Charlotte Storm Water
600 East Fourth Street
Charlotte, N C 28202-2844

Rezoning Petition Review

Date of Review: September 27, 2021 ***(Revised November 29, 2021)***

Rezoning Petition #: 21-112

RZ-2: PARCEL IDENTIFICATION PLAN

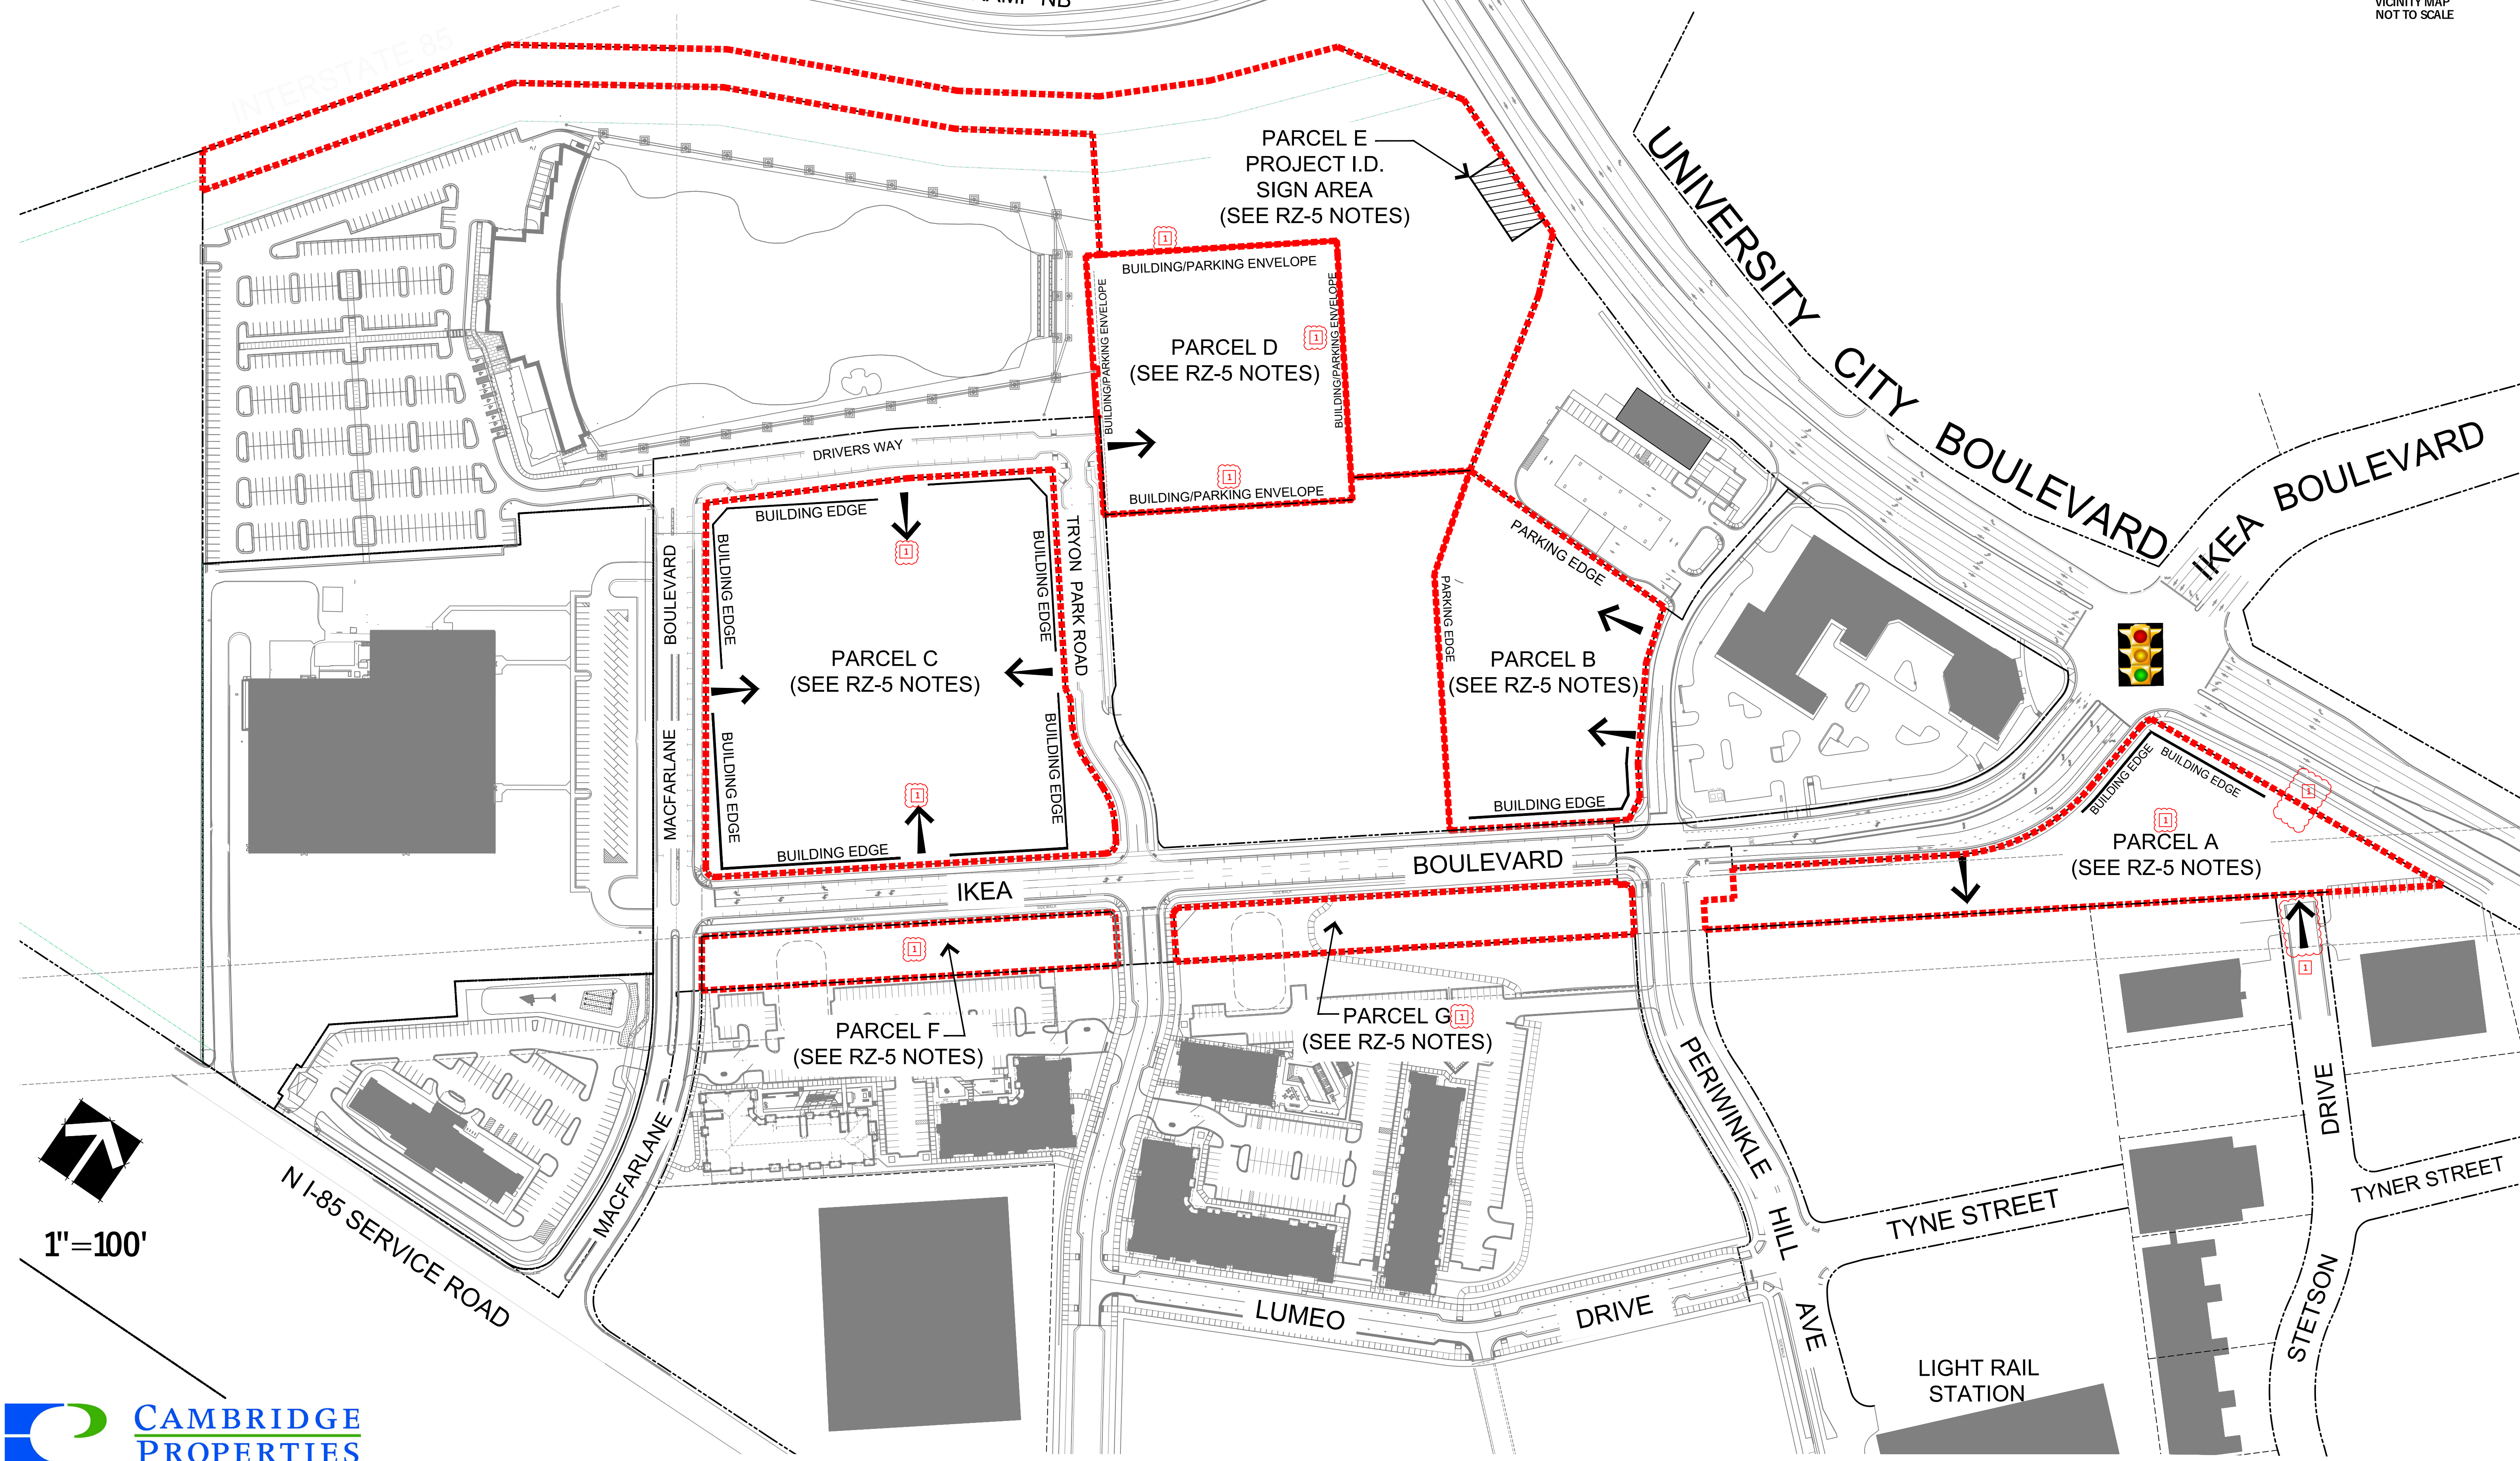
Due to revisions (11/29/21): City of Charlotte GIS indicates a 35-ft SWIM Buffer and a 100-ft Undisturbed PCSO Buffer on site. Please show and label potential SWIM/PCSO Buffers on the site plan.
